Good morning Jeff;
I am not sure who's project this is, but the Kraemer Short Plat SP-06-125, has met all of the KRD requirements. If you have any questions, please let me know.
keli

TO: Community Development Services
FROM: Christina Wollman, Planner II *cw*
DATE: December 19, 2006
SUBJECT: Kraemer Short Plat

We have received the proposed Kraemer Short Plat, located in Section 19, Township 18N, Range 19E, off of Wilson Creek Road. We have also received the \$240.00 plat submission fee.

KRAEMER PROPERTY

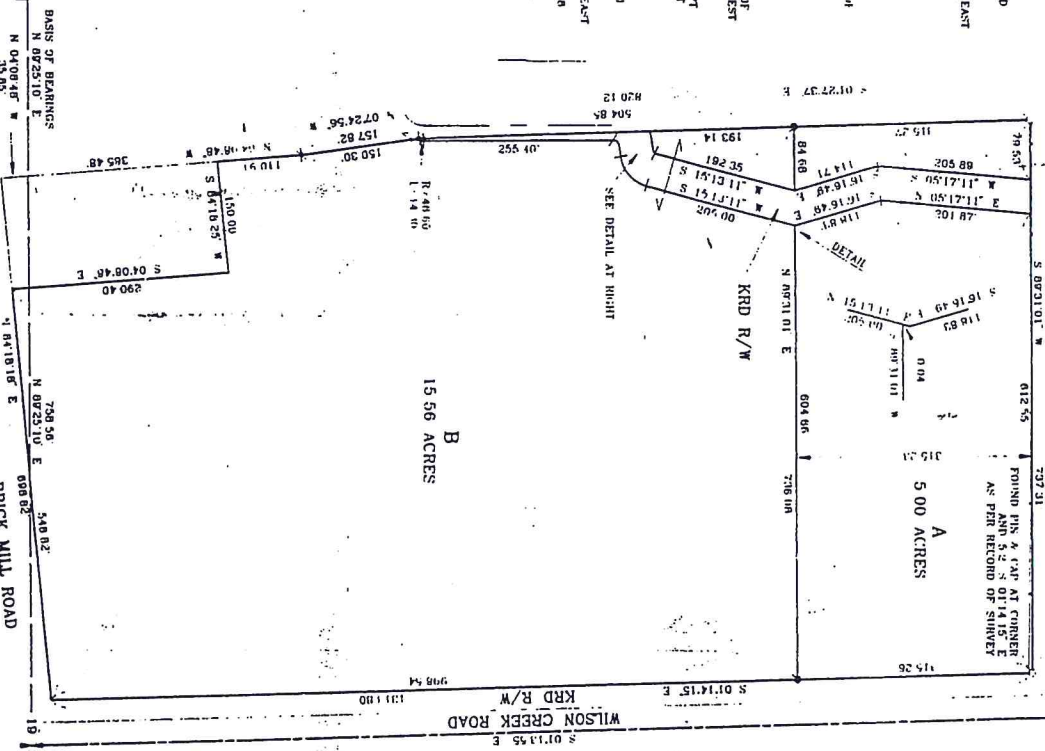
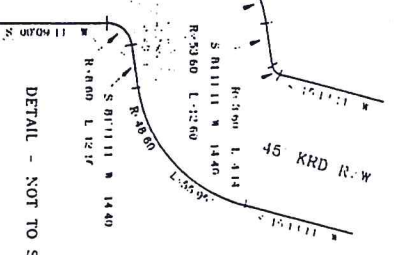
3. KRD Right of Way: Access from Wilson Creek Road appears to cross a KRD right of way. Contact KRD for any additional requirements or permits.
4. Easements: The location and width of all existing and proposed access and utility easements shall be shown with broken lines on the face of the plat. Bearing, distance, and width shall be shown. A description of all easements shall be included.

5. Accesses: All existing and proposed accesses shall be shown on the face of the plat. This includes the current access to the house on Lot B-1, the proposed access to Lot B-2, and any other accesses proposed or existing.

6. Plat Notes: Plat notes shall reflect the following:
 - a. Plat note number 5 shall be removed.
 - b. The second sentence of plat note #4 is incorrect and shall be edited. The second sentence shall read: See Kittitas County Road Standards.
